Our Ref: 8441/CND Condition 15

**Re: 42 BEECH HILL, ENFIELD, EN4 0JP
Town & Country Planning Acts 1990 (Amended)
Application for Discharge of Condition 15 (Landscaping) attached to
planning permission 22/00735/FUL**

15.1 Planning Condition 15 document prepared by Evergreen & Gorgeous dated 28.03.2024

address 42 BEECH HILL		
drawing name PROPOSED SOFT LANDSCAPING		
drawn by JC	drawing number EG-LP-01	checked by PF
job number 2943	scale 1:200 @ A3	date 28.03.24

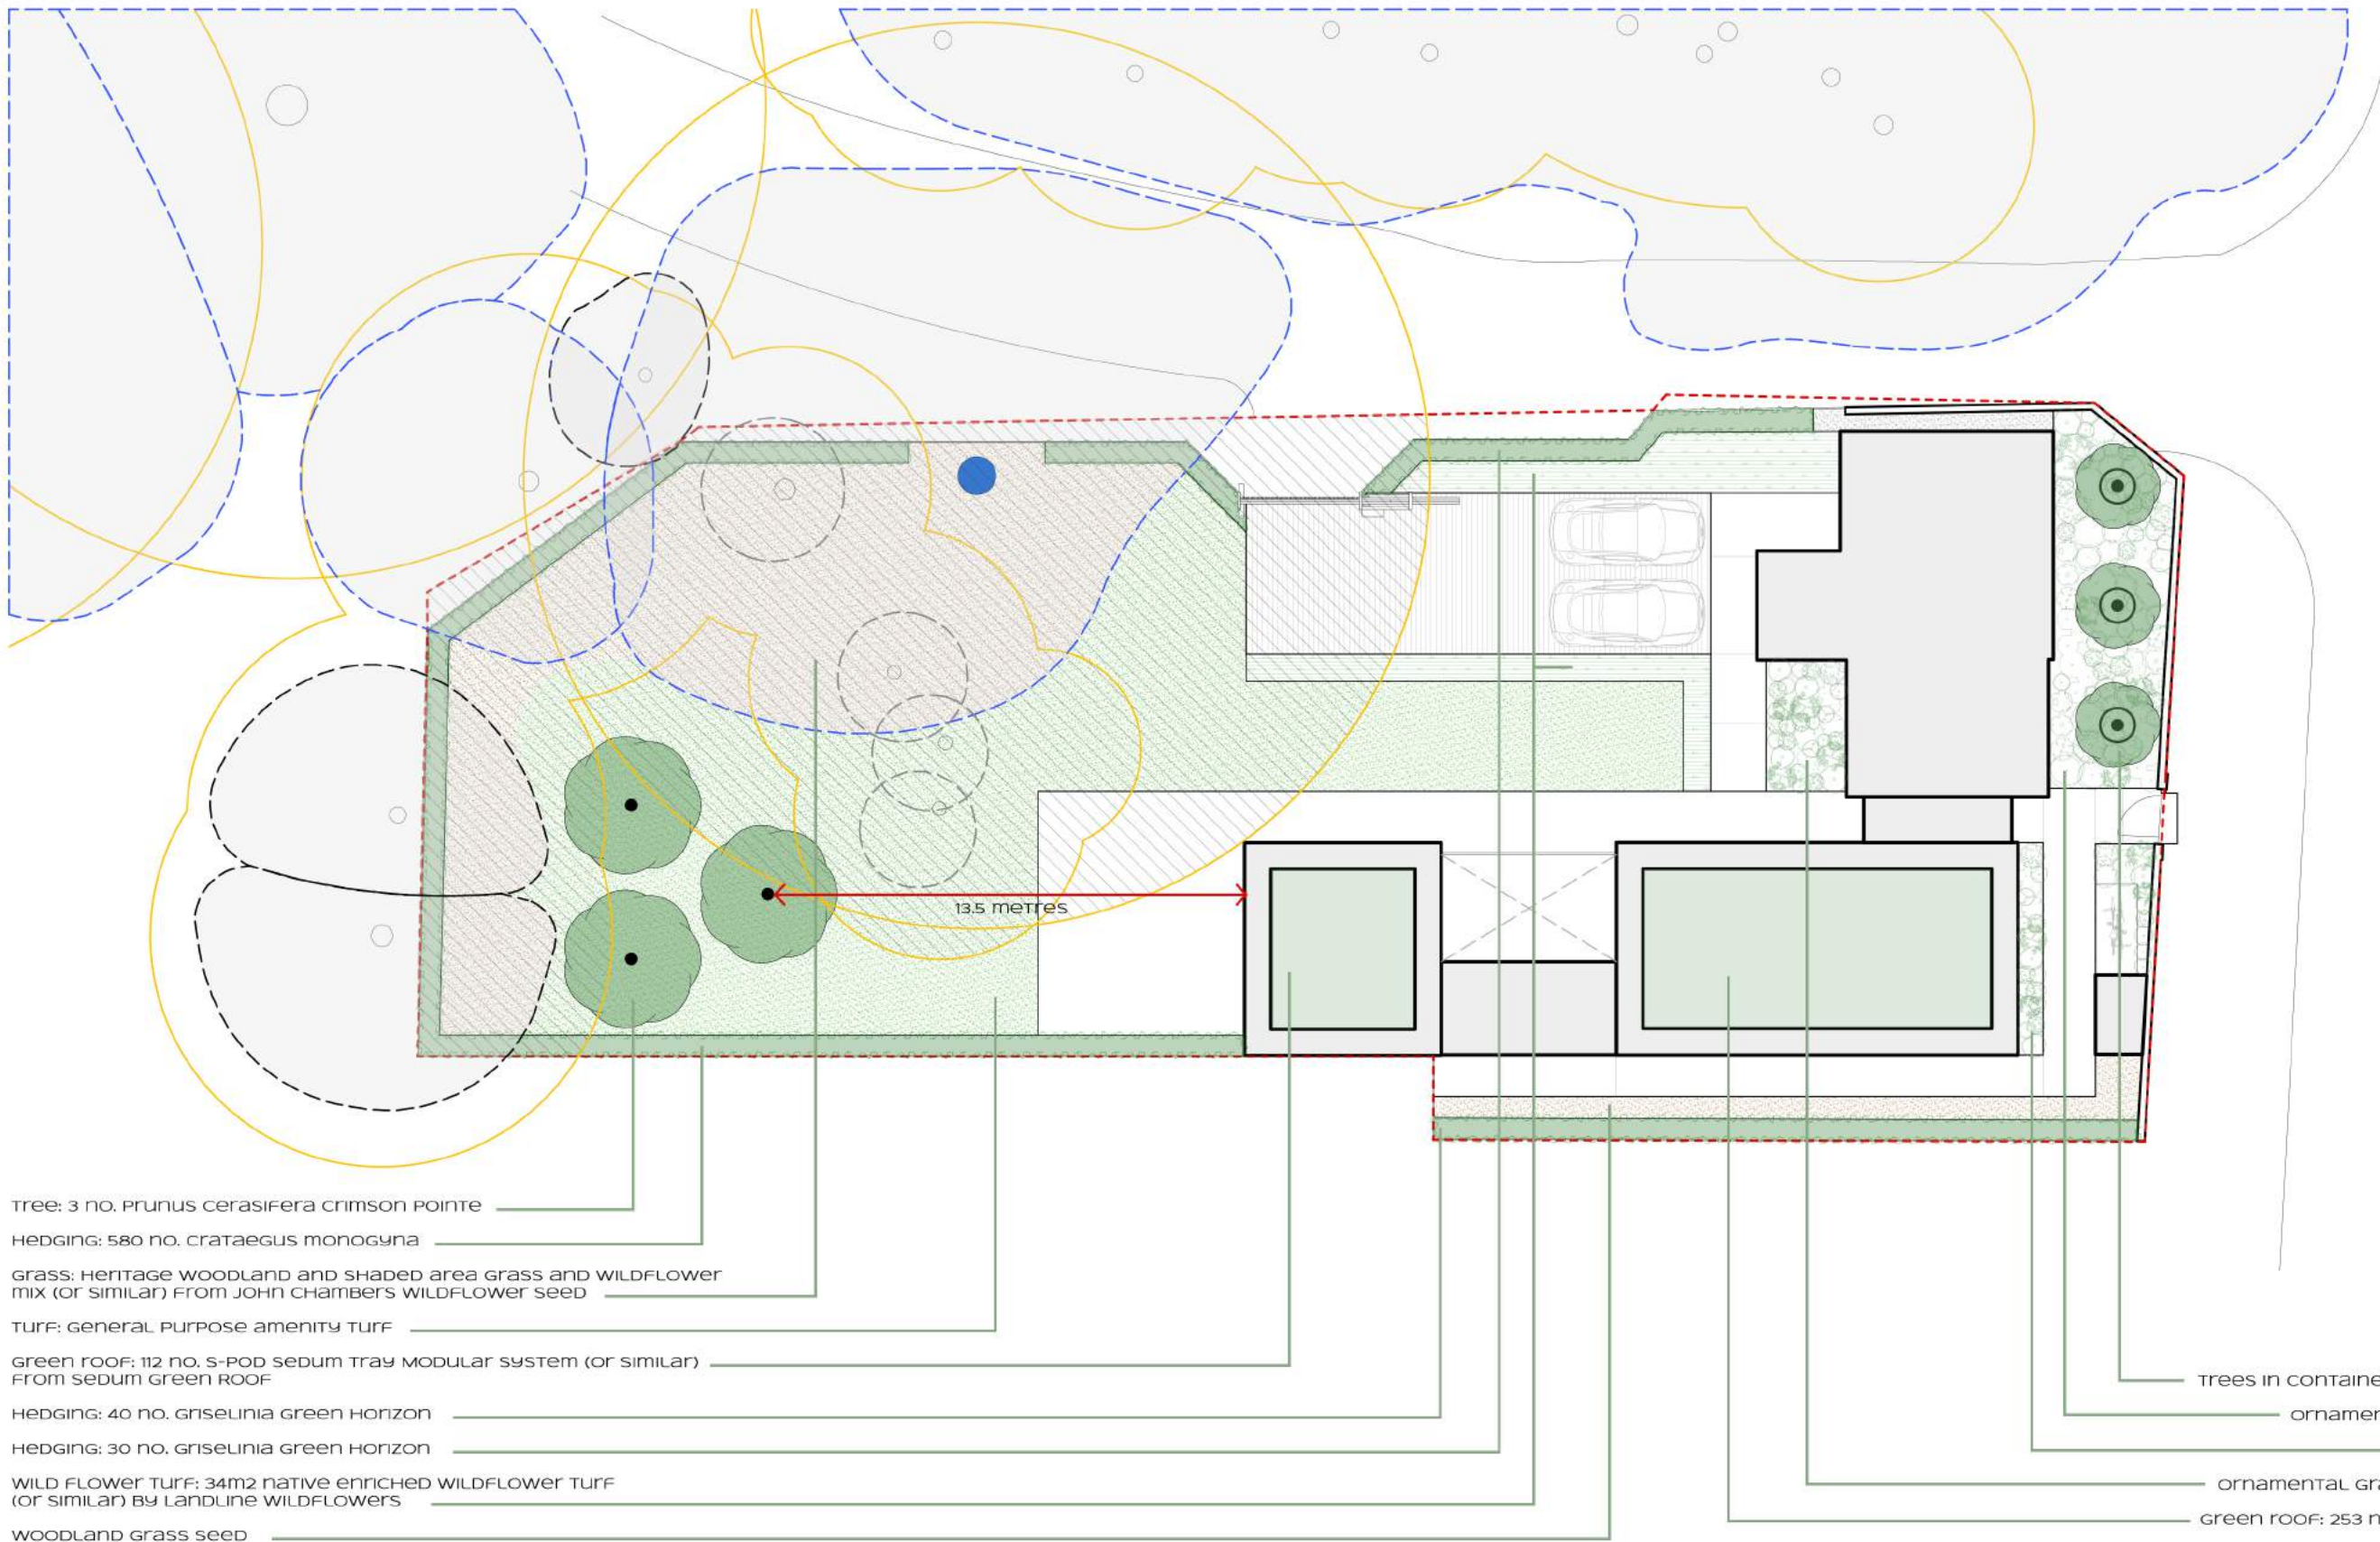
- A number of proposed trees are shown very close to retained mature trees. There is insufficient space for their establishment and excavation for planting, (identified in document entitled 'Notes') will sever retained tree roots (for example, T20 oak and T24-T26 Lime).

- Other proposed trees are too large for the available space.
- Other Site Preparation works described in 'Notes' will also damage retained trees.
- No information on proposed hard surfaces hard surfaced amenity areas
- Underground drainage storage is proposed within the Root Protection Area of T20 mature oak and will sever tree roots

- Review tree planting design and specification to cross reference with information provided in the tree report.
- Re-submitted planting plan to show canopy spread of retained trees (where overhang garden) and the early mature canopy of proposed trees (e.g. canopy at 20 years) in order to demonstrate the relationship of proposed trees with buildings and retained trees.
- Review BS8545:2014 Trees: From nursery to independence in the landscape – Recommendations to inform tree planting specification.
- Review specification of ground preparation and soft landscaping so it is compatible with retained trees.
- Resubmitted plan to confirm that new tree planting will be compatible with drainage and other utilities.
- Resubmitted plan to confirm that and that proposed building foundations will accommodate long term requirements of new trees.
